**KIRKLEES METROPOLITAN COUNCIL
INVESTMENT & REGENERATION SERVICE**

DELEGATED DECISION TO DETERMINE PLANNING APPLICATIONS

Reference No:	2025/62/90015/E
Site Address:	126-128, Huddersfield Road, Mirfield, WF14 8AB
Description:	Alterations to convert 1 unit into 2 units and change of use of unit 128 to use class EC(i) Estate Agency and Unit 126 to use class EC(iii)
Recommending Officer:	Nicole Helliwell

Officer Report

DRAWING DESCRIPTION  
AS PROPOSED PLANS AND ELEVATIONS

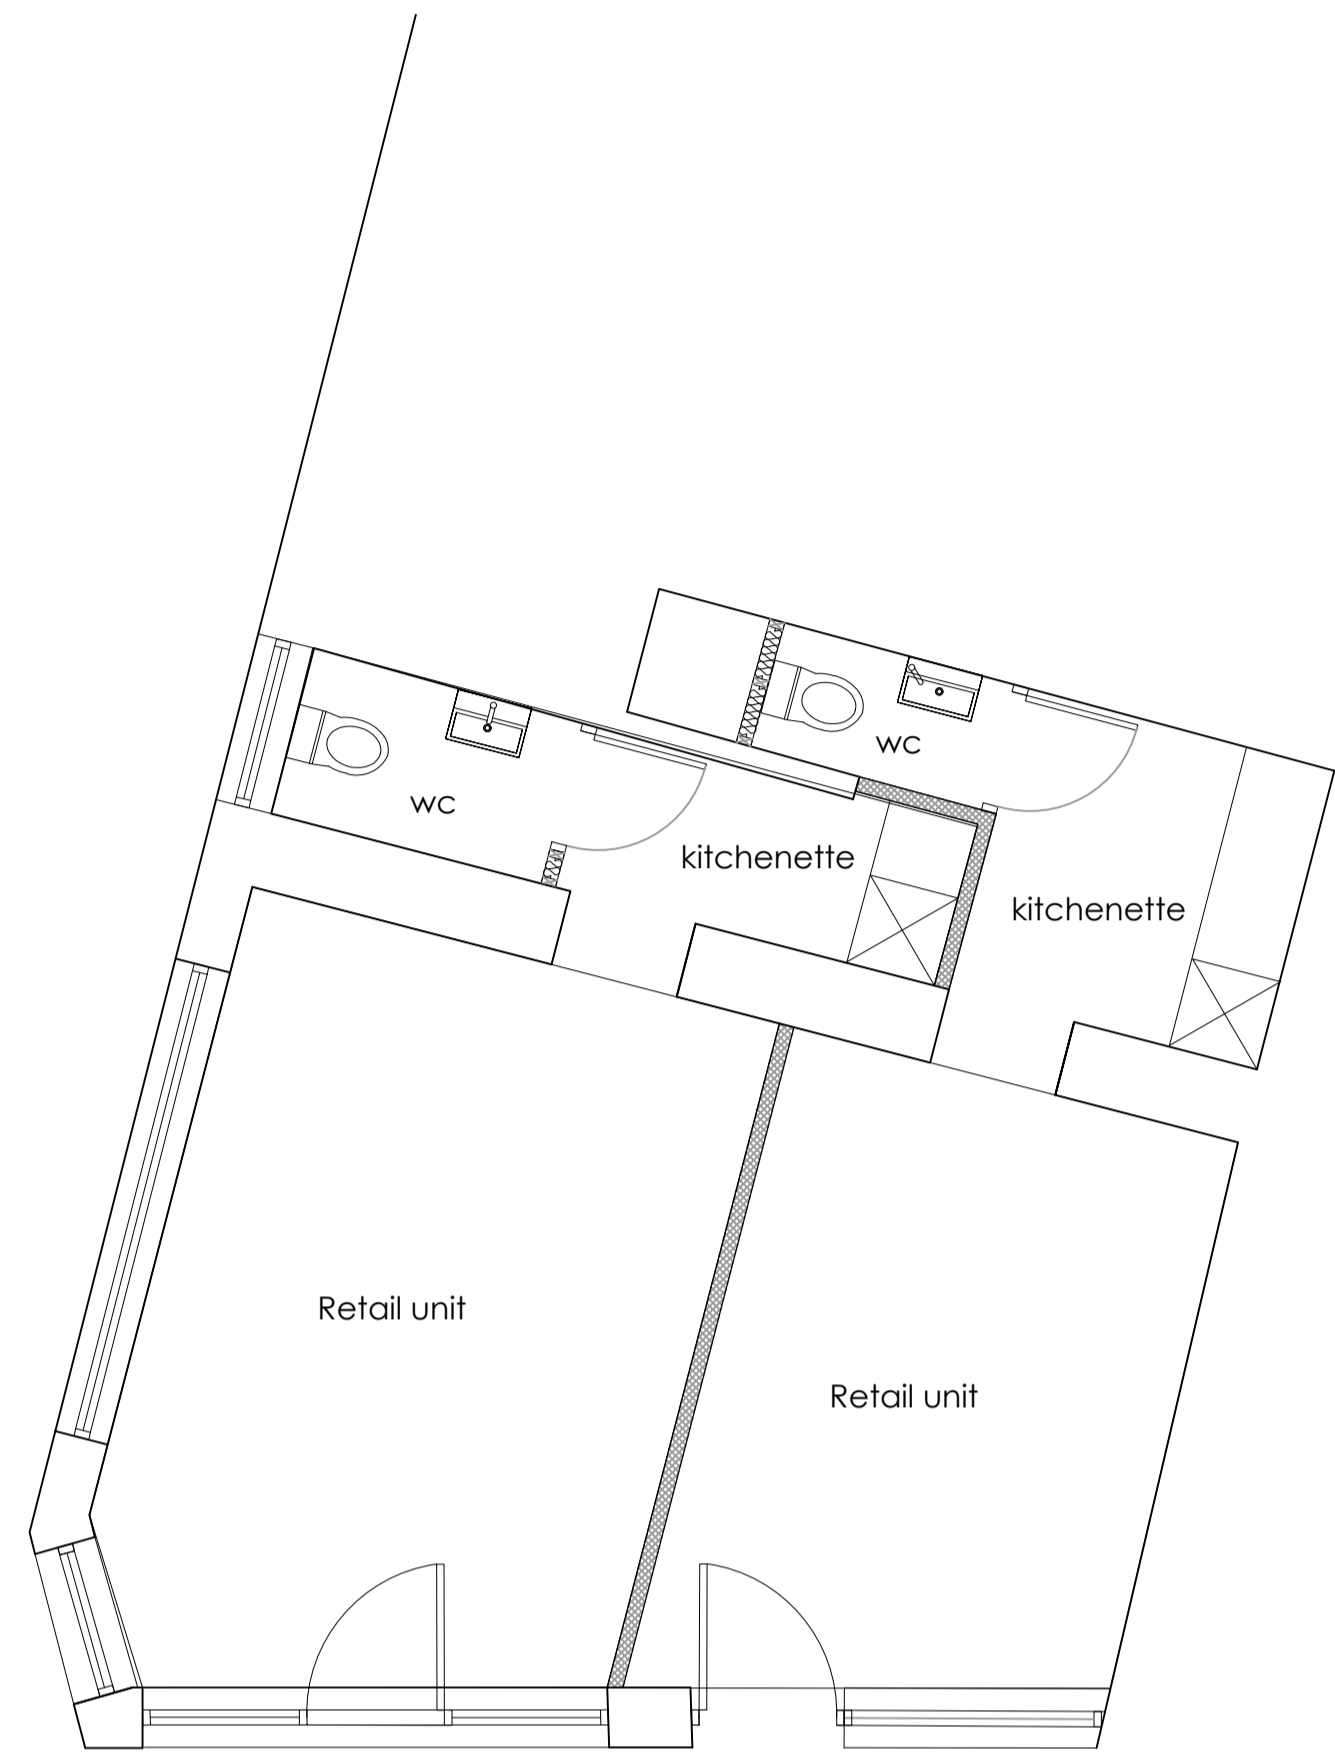
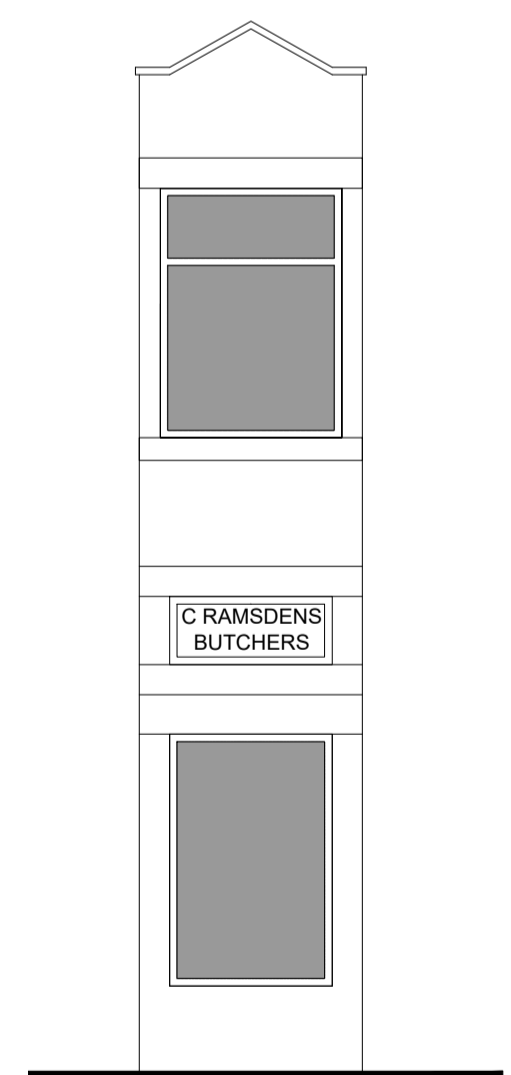
Amendments were sought during the course of the application. KC Highways Development Management initially objected to the proposal with regard to

highway safety. Officers confirmed that the proposed door in the south-west elevation would be on the entrance to the car park from the A644 Huddersfield Road and would have very poor pedestrian inter-visibility between customers exiting the shop and vehicles exiting the car park. A request was made to relocate the proposed opening to the southern elevation of the building. Revised plans were received which were considered acceptable with regard to highway safety.

Development Management. Revised drawings were provided which were considered acceptable with regard to highway safety.
